Application for a non-material amendment following a grant of planning permission.

| Property name                                                            | Land At Salt Box West Of |

Reference number: BE/135/18/PL

DRIVE THRU 2
PROPOSED SECTIONS
1744-DT2-P04-B

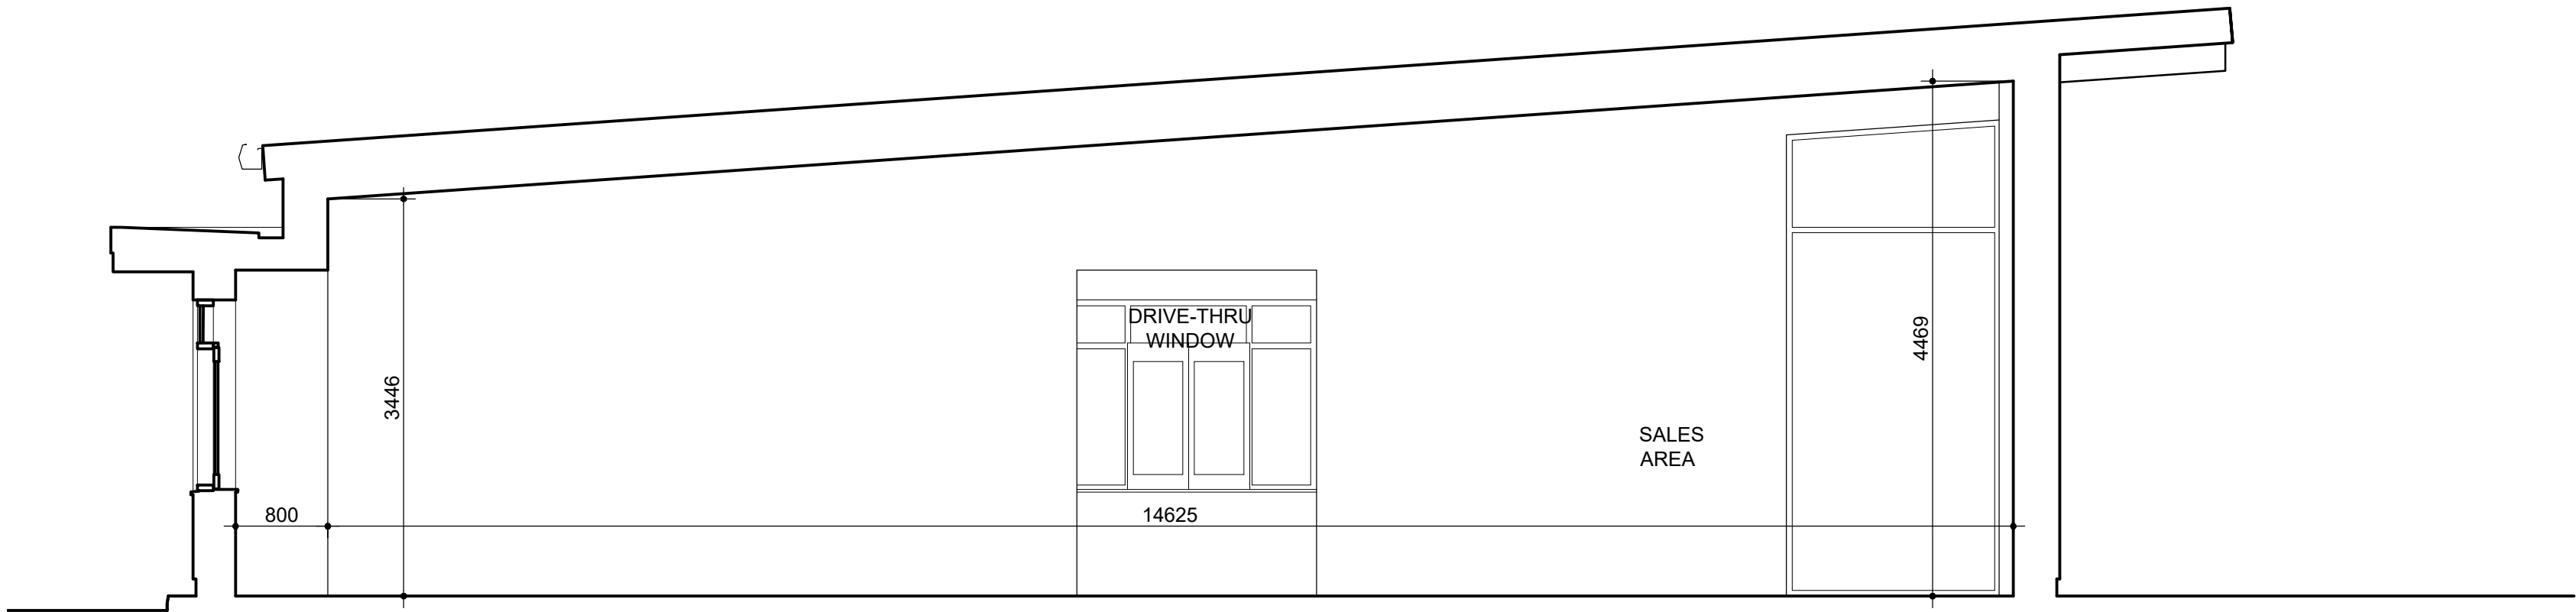
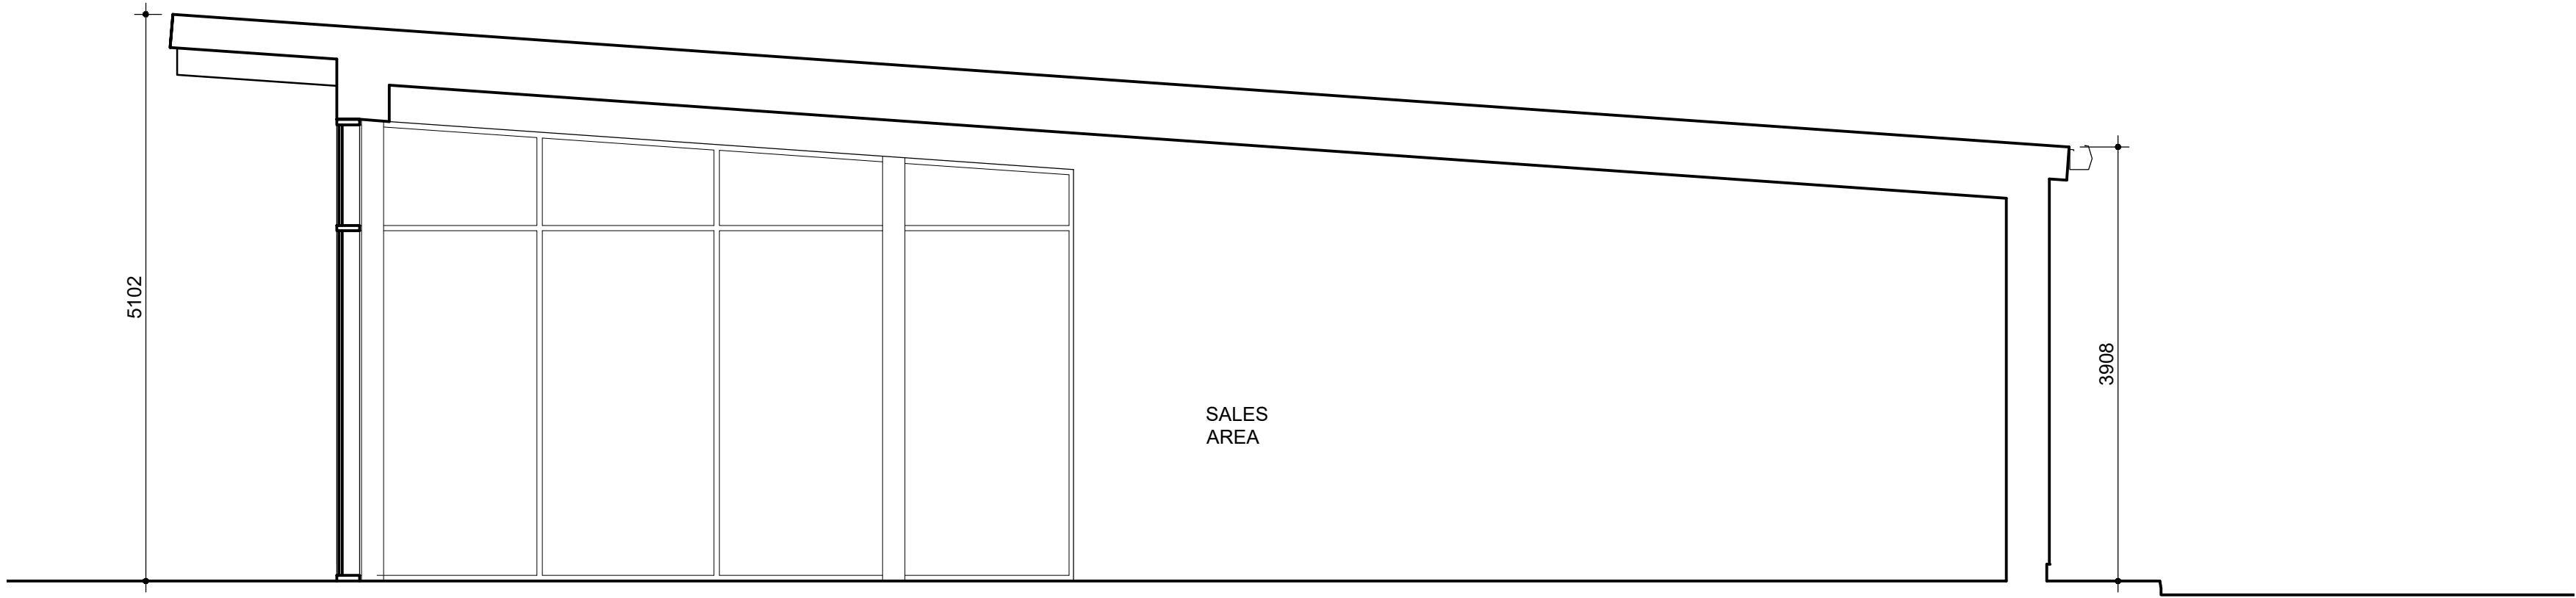
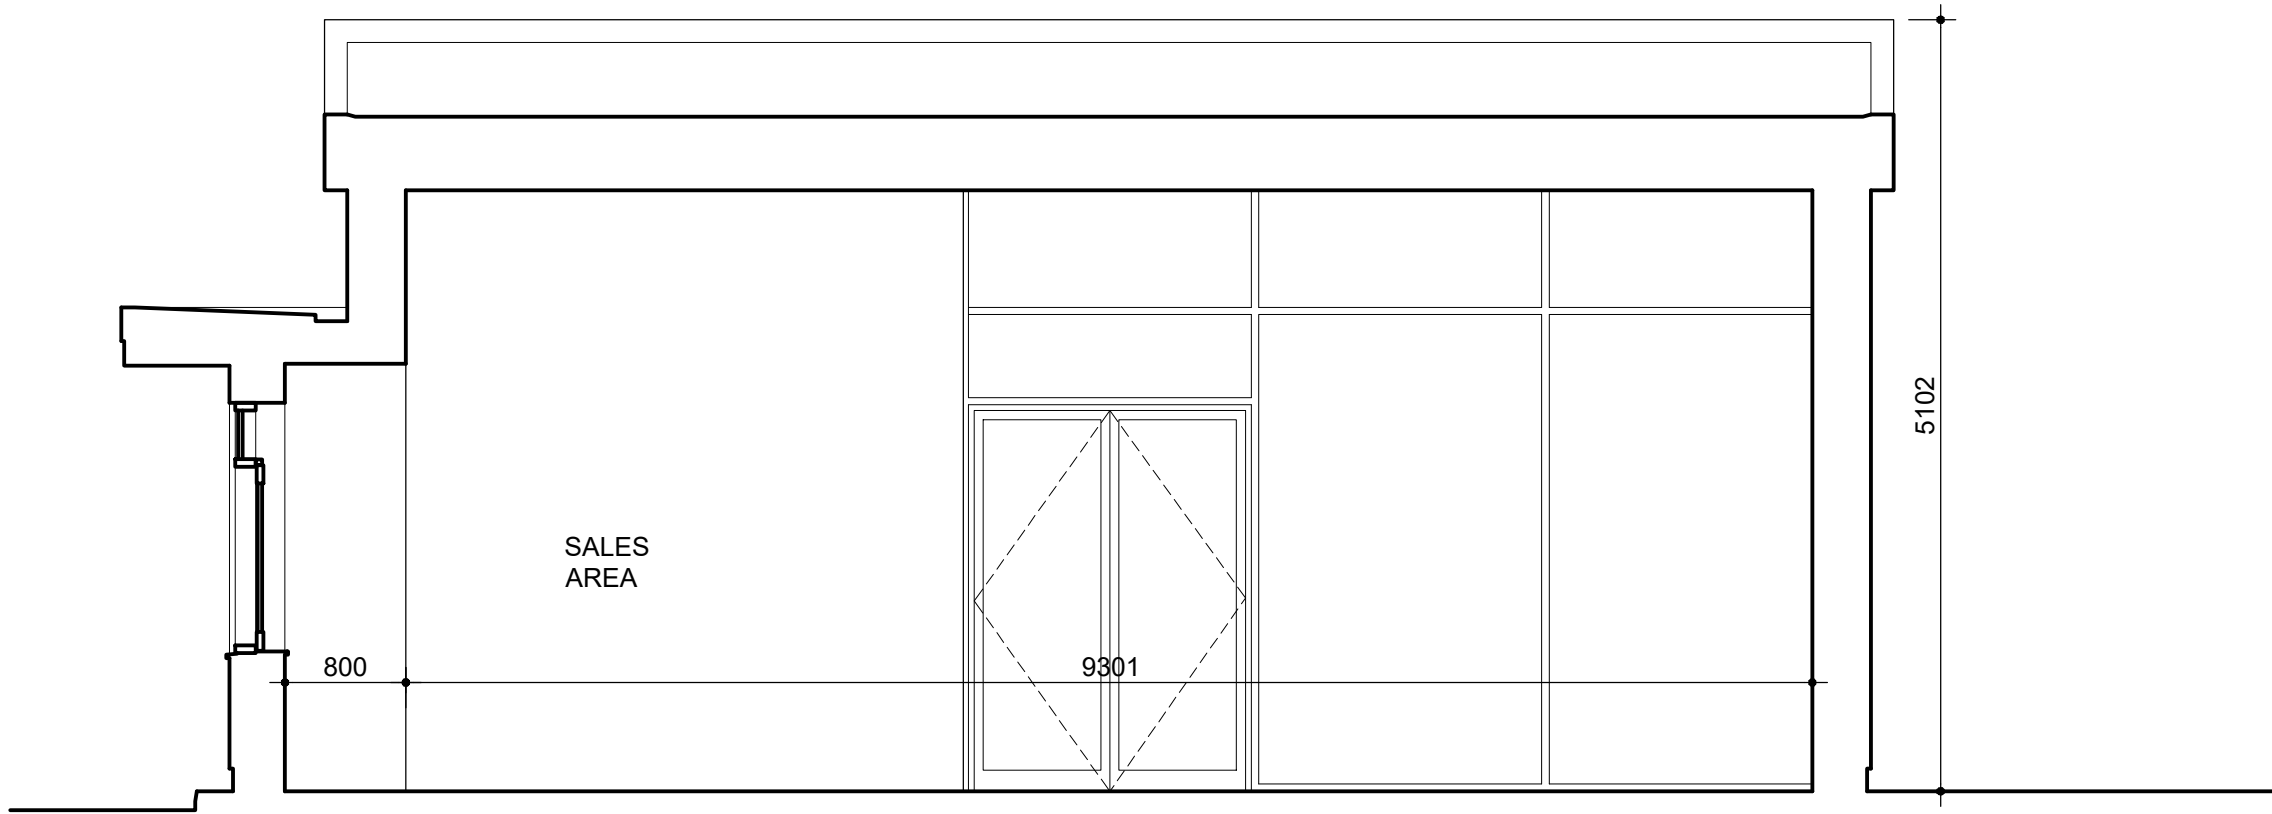
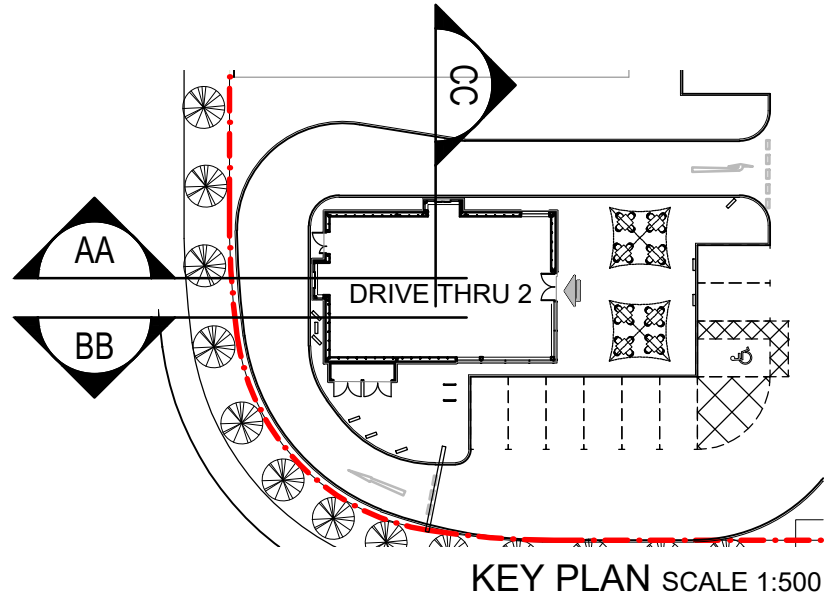
Unit 5 plans, elevations and sections updated to include: Canopies over drive-thru windows added, drive-thru windows revised, curtain walling mullions/transoms re-positioned, roof colour corrected, cantilevered beams added to roof overhang
